Application No: EP/71/26/HH
Site Address: 51 Warren Crescent East Preston BN16 1BL
Description of works: Extension to the side and infill extension to the rear, new roof and loft conversion and alterations to fenestration including removal of front porch.

OWPC86296

Project	ARCH2026_WaCI-R	Sheet
Date	30.06.2026	A105-C
Scale	as stated	
PLANNING ISSUE

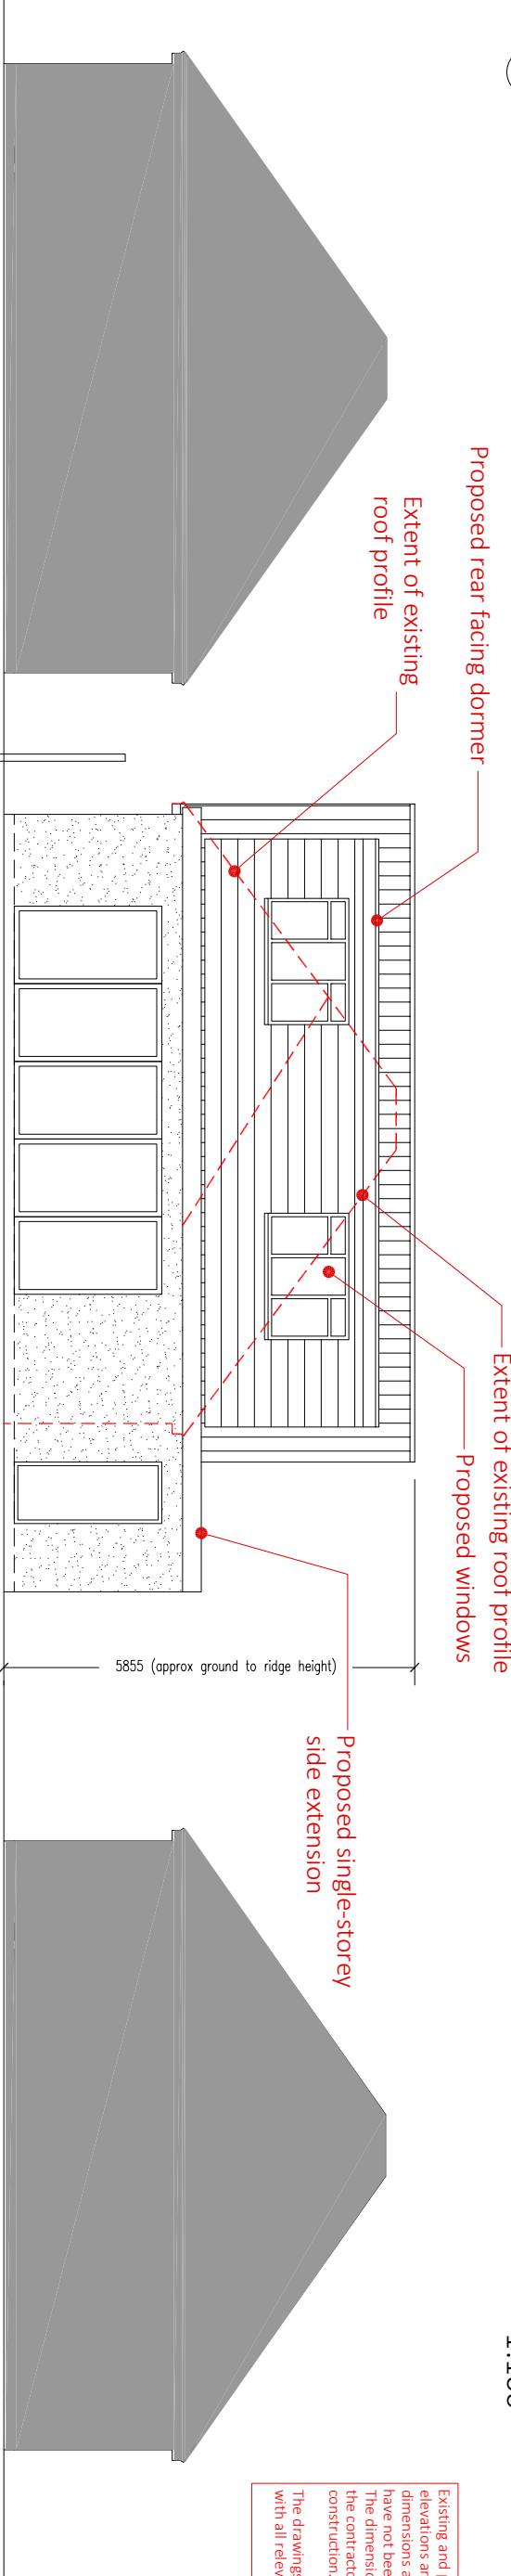
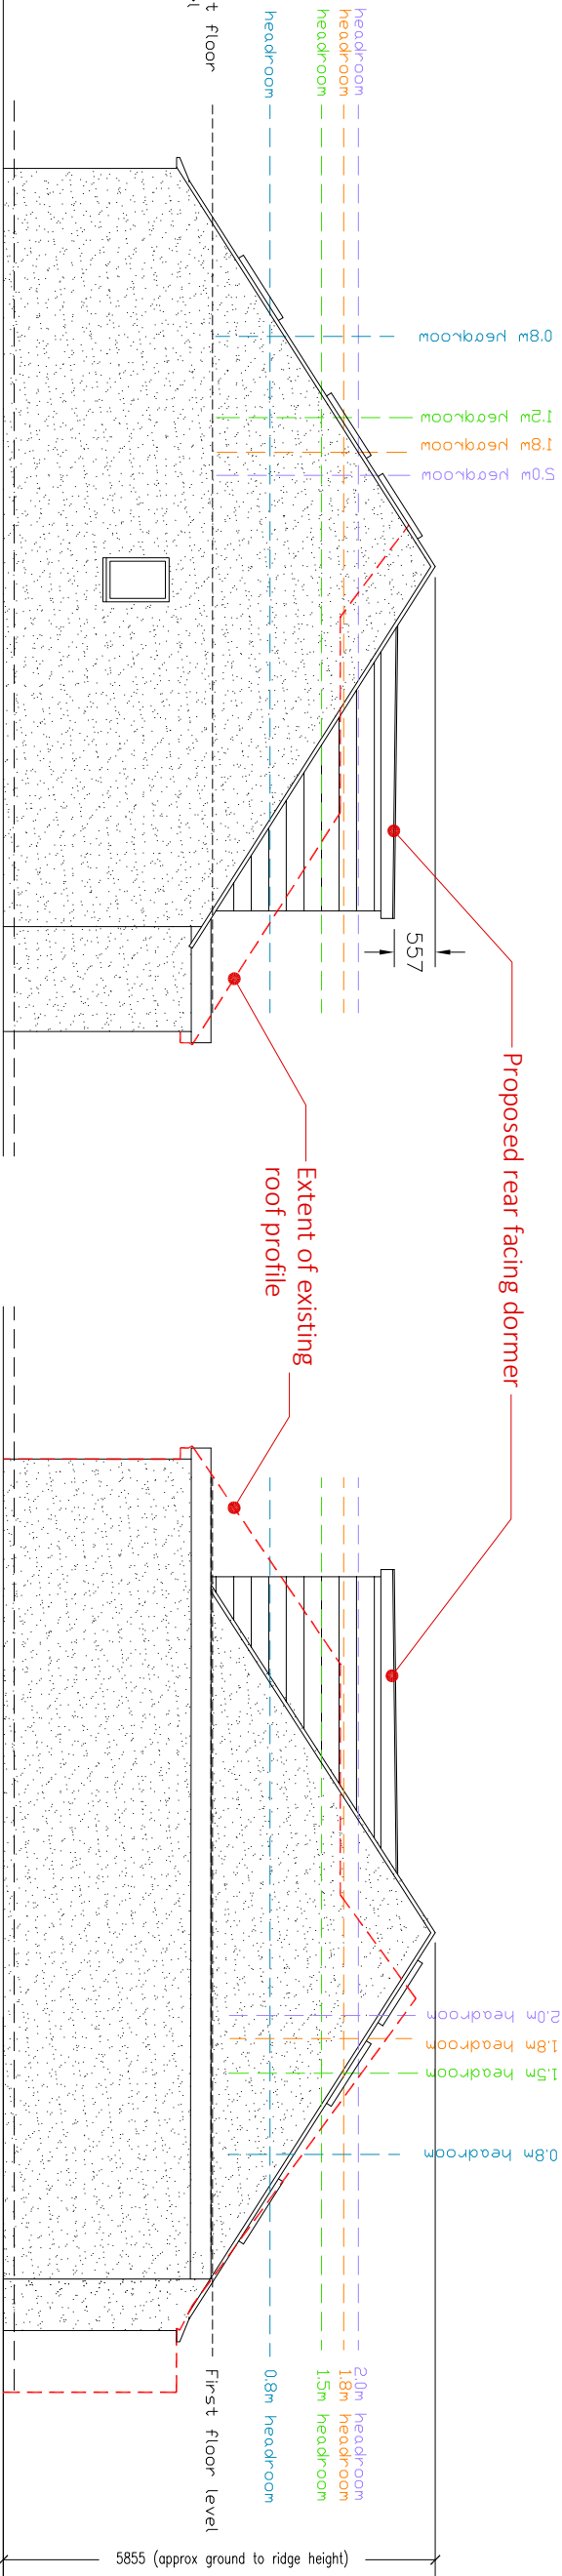
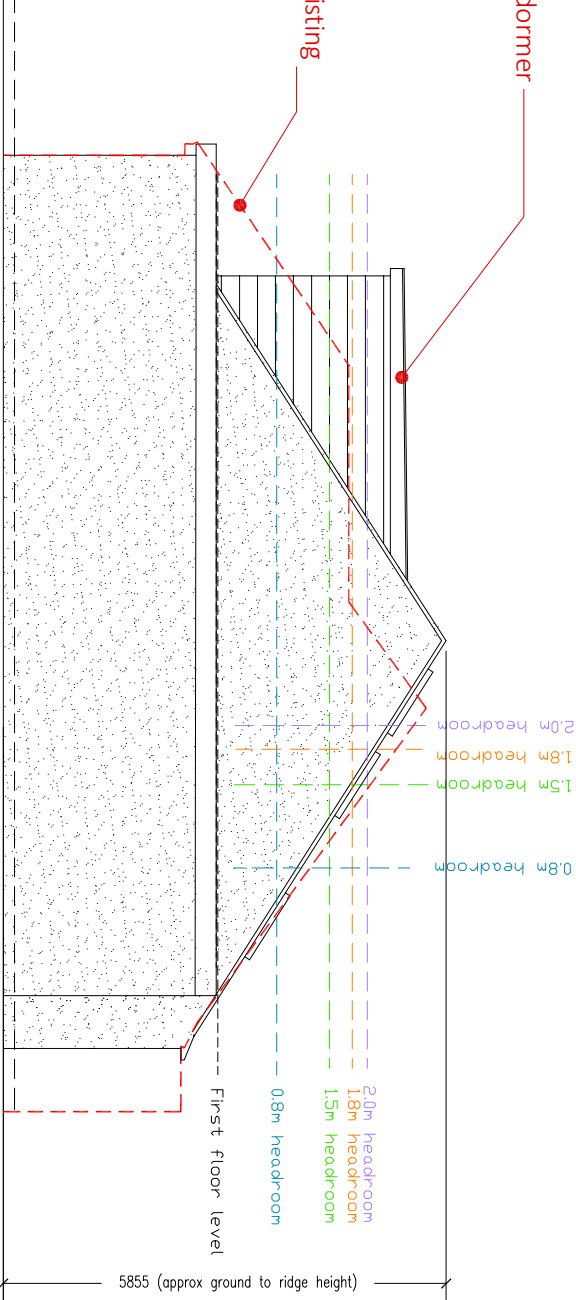
I write on behalf of the East Preston and Kingston Preservation Society to object to this application. The proposed structure would present an uncompromisingly square profile to the street view, without even the mitigation of half hips to soften this profile and thus totally out of keeping with the rest of this street of compact properties which feature steeply sloping roofs, with the impact emphasised by the planned increase in roof height. The design thus contravenes Policies 1i and 3ii of the East Preston Neighbourhood Plans (EPNP and the emerging EPNP 2) and does not follow the design guidelines in the East Preston Village Design Statement nor those in the Village Design Guide attached to the emerging reviewed Neighbourhood Plan (EPNP2). We also feel that the side extension to the boundary with no.49 constitutes overdevelopment of a small plot. We would also point out that the irregular placement of rooflights on the front elevation contravenes paragraphs 4.15 (EPNP) and 4.13 (EPNP2) "- Irregularly spaced rooflights at the front of a building should be avoided."
